**MAJOR PROJECT ASSESSMENT:
157 Redfern Street, Redfern
(MP09_0039 MOD 2)**

Director-General's
Environmental Assessment Report
Section 75W of the
Environmental Planning and Assessment Act 1979

November 2011

HEIGHT LIMITATIONS VARIABLE THROUGHOUT EACH FLOOR PLAN AND TO BE ADDED ONCE FINAL FIELD SURVEY HAS BEEN UNDERTAKEN

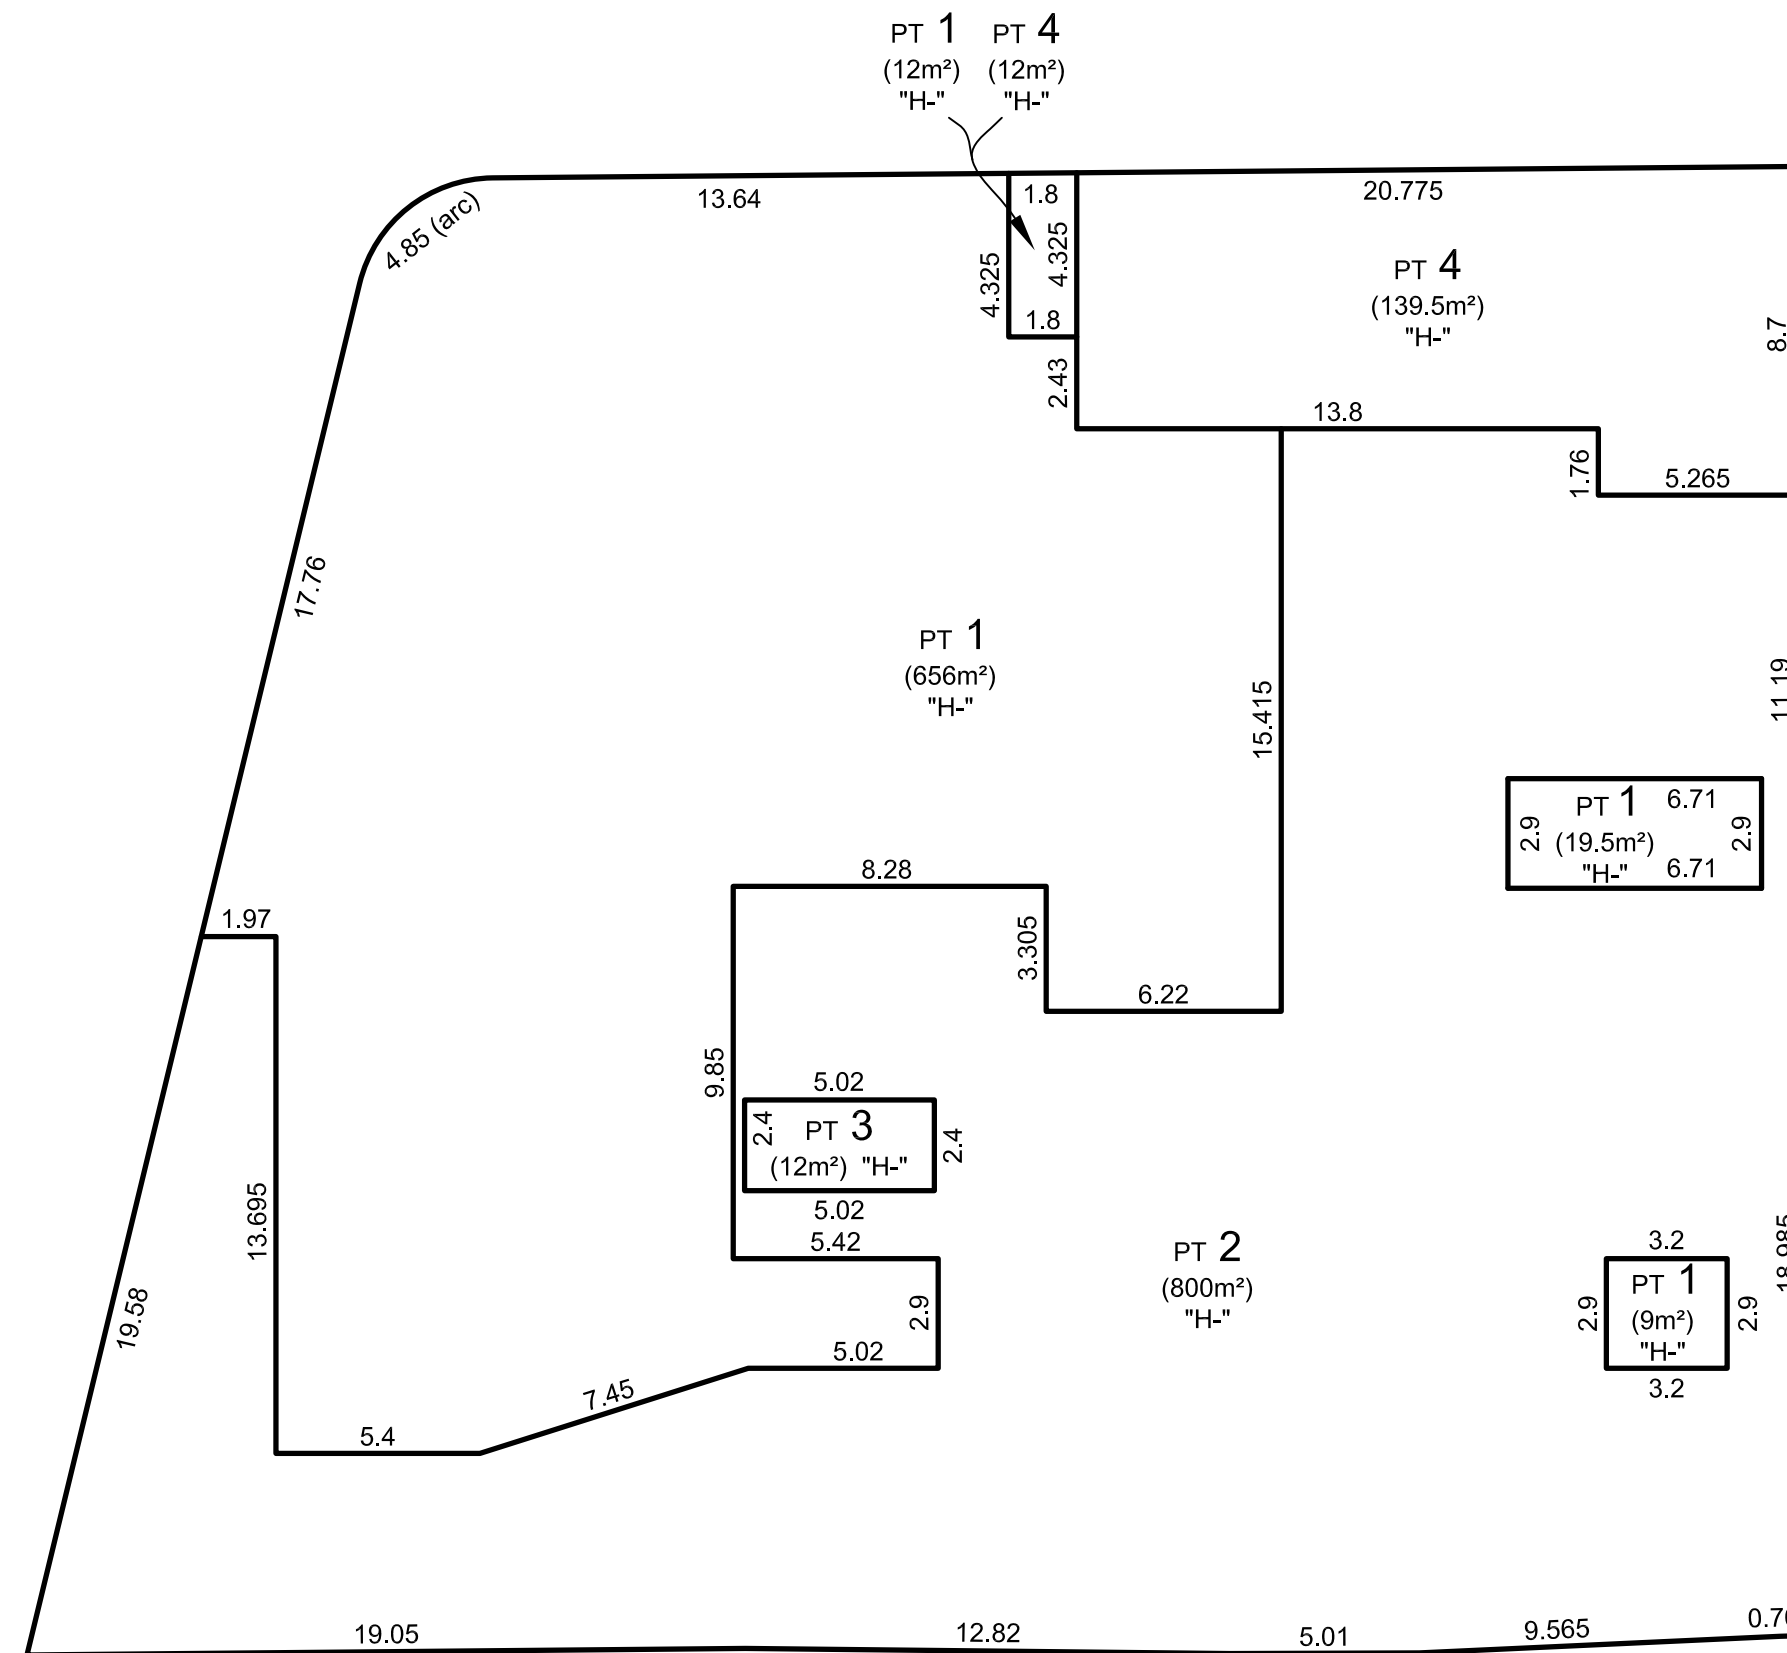
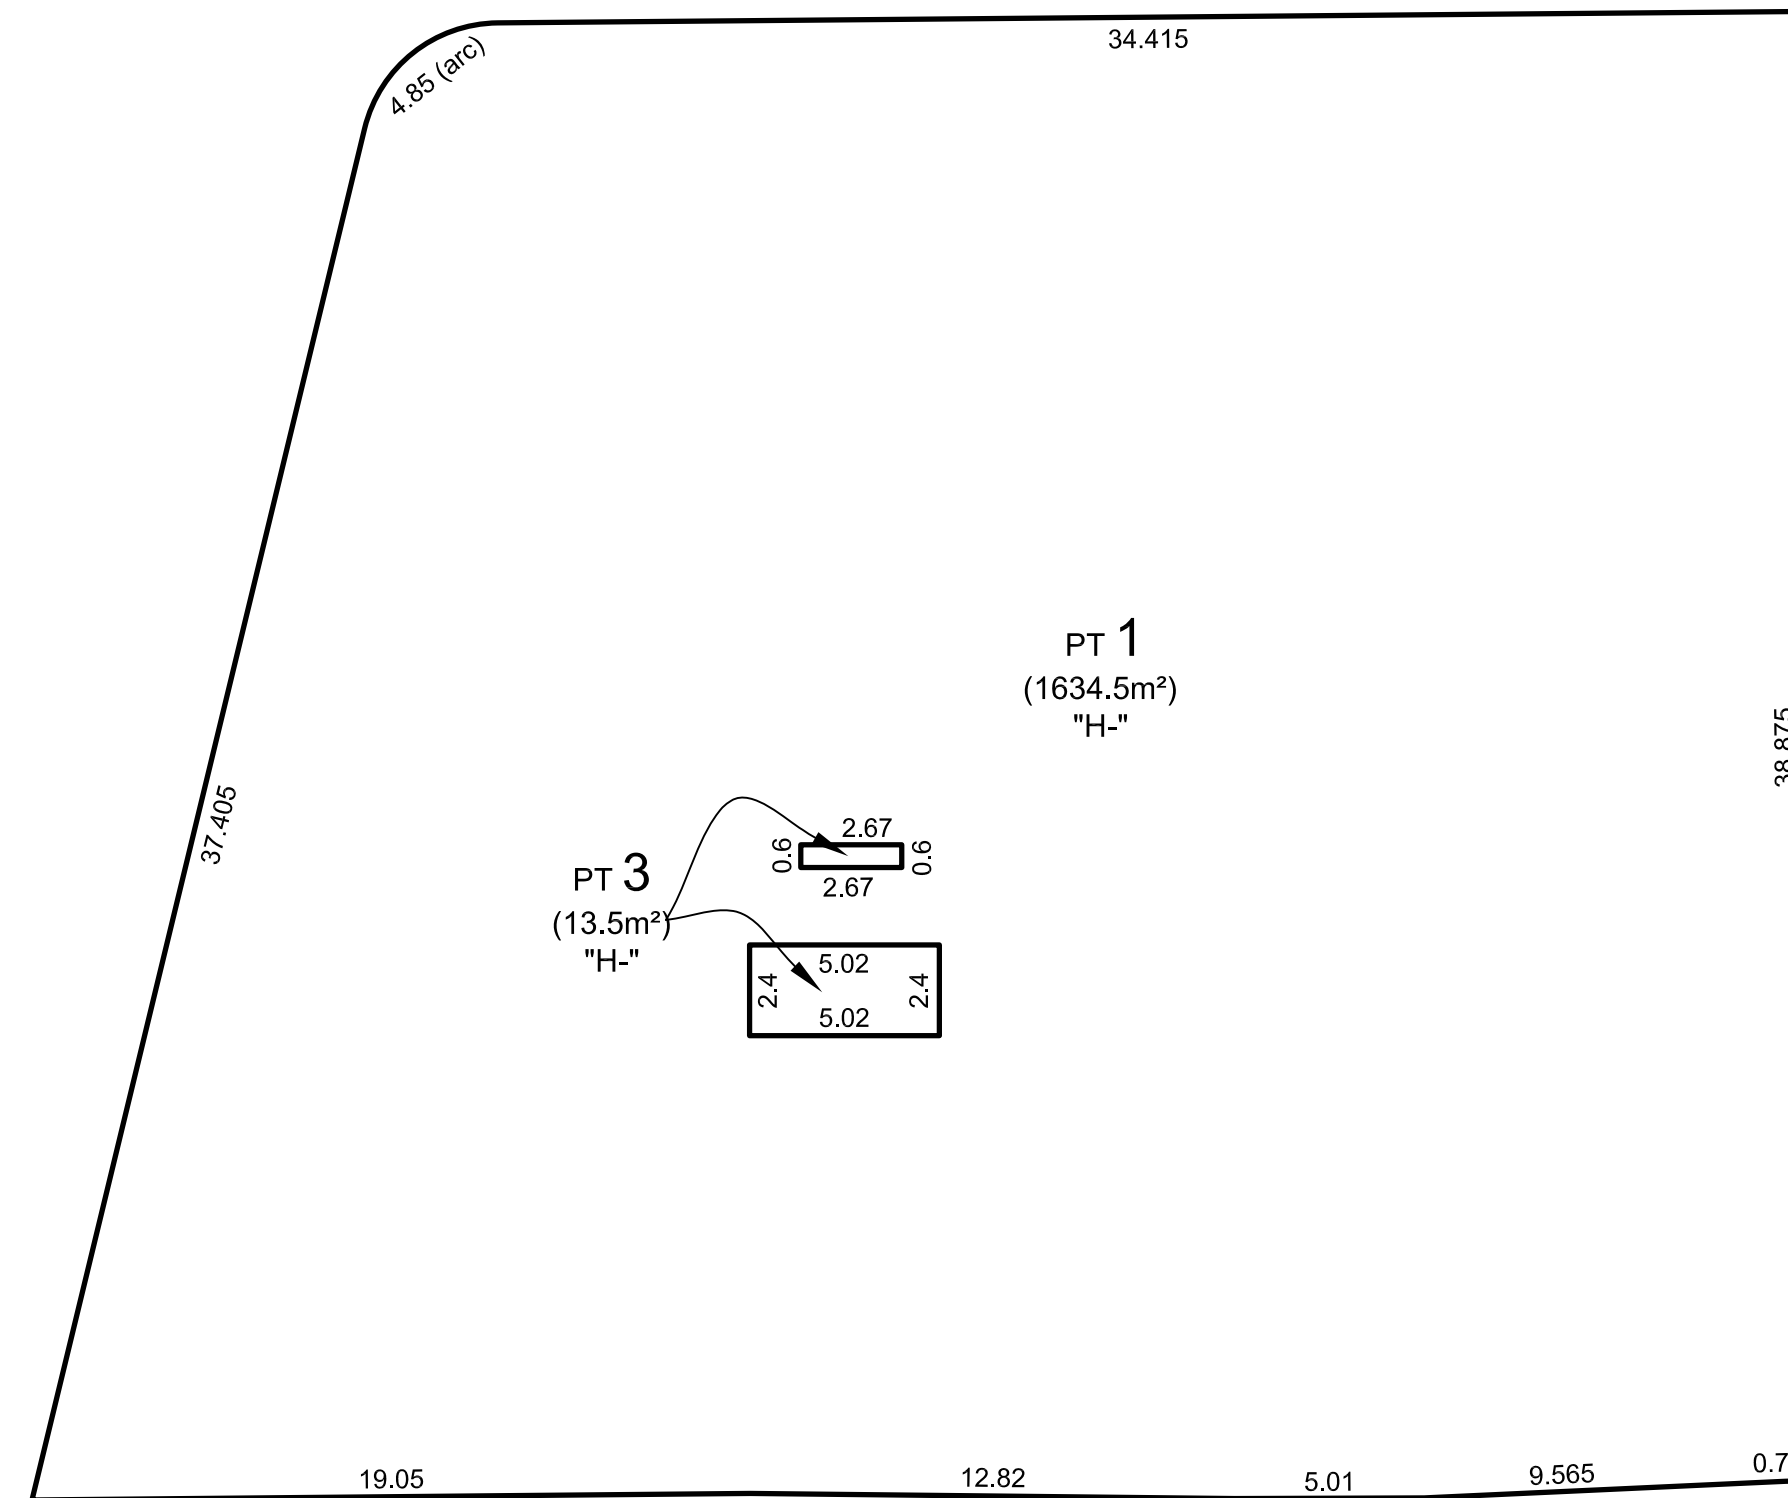
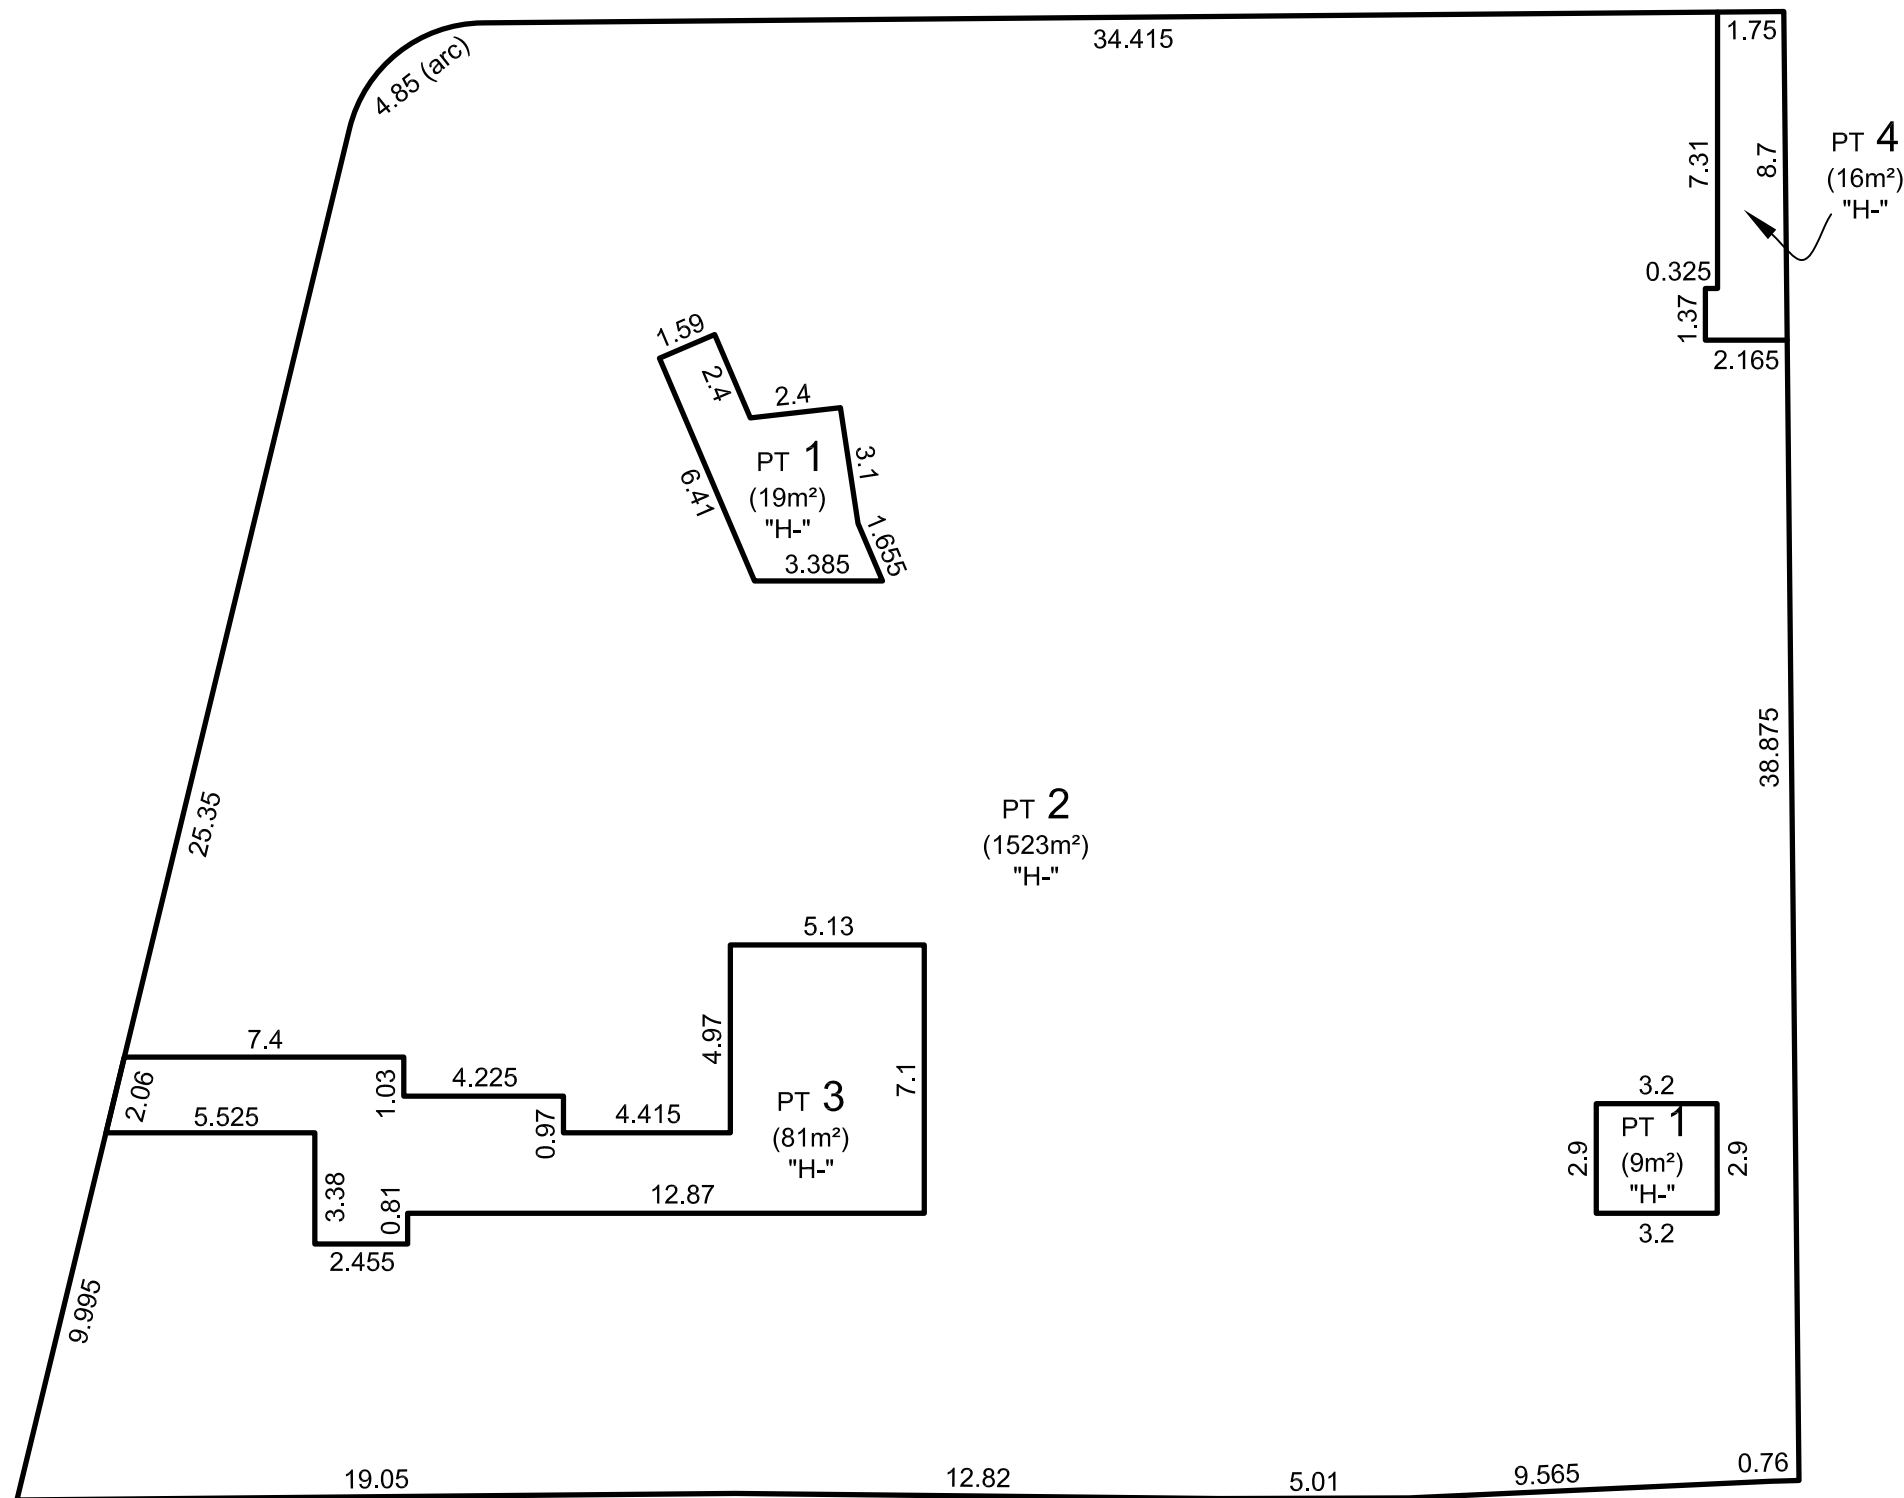
The Proponent requests the residential and commercial office components and respective car parking areas be contained within discrete stratum allotments to facilitate satisfactory and appropriate ongoing management. It is proposed to subdivide into 4 stratum lots, as follows:

- Lot 1 – RSL Club;
- Lot 2 – ground floor retail and two levels of commercial offices;
- Lot 3 – 14 levels of residential apartments; and
- Lot 4 – building services and associated access ways.

The proposed stratum subdivision is considered satisfactory as it will enable the above uses to operate independently and efficiently.
